Your Ref: 100665101-002
Our Ref: 24/00831/LBC

Date 11th April 2024

Application No: 24/00831/LBC
Proposal: Listed building consent for proposed rear ground floor extension and removal of existing bay window to rear of property
Address: Rosemay High Street Elie Leven Fife

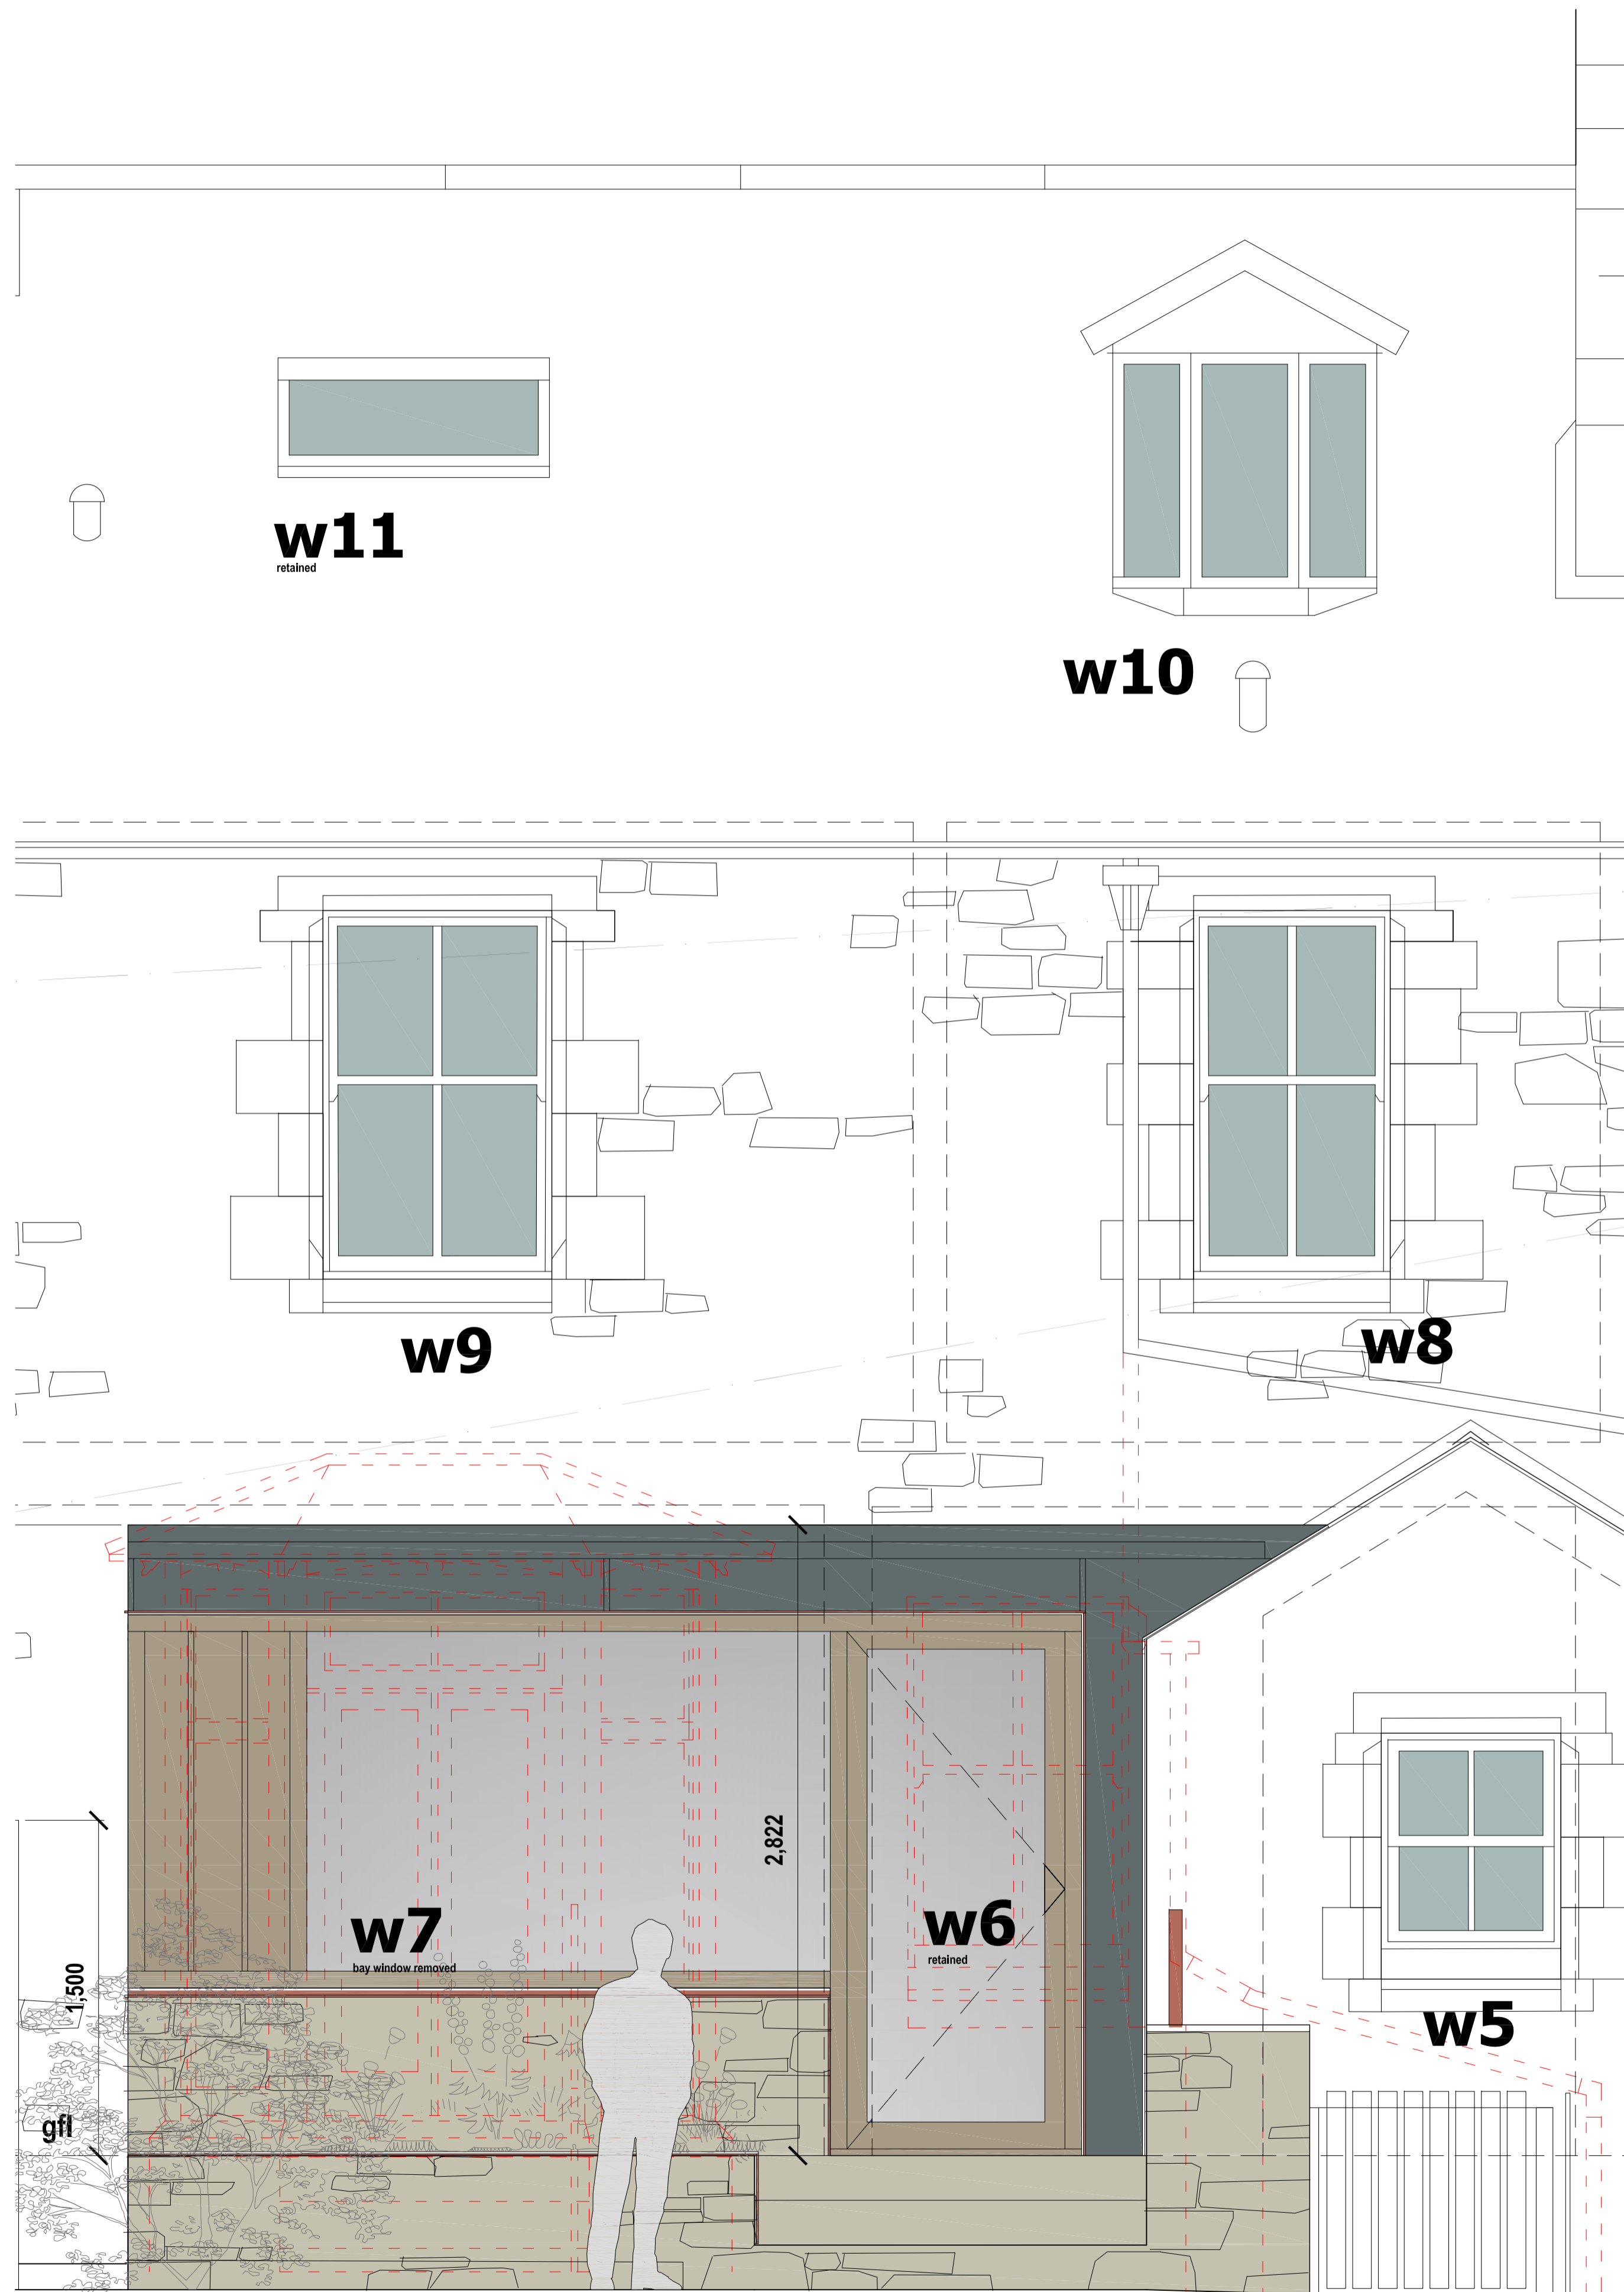
1. You have not submitted existing and proposed window elevations at a scale of 1:20. If applicable please submit existing and proposed astragal details at a scale of 1:1.
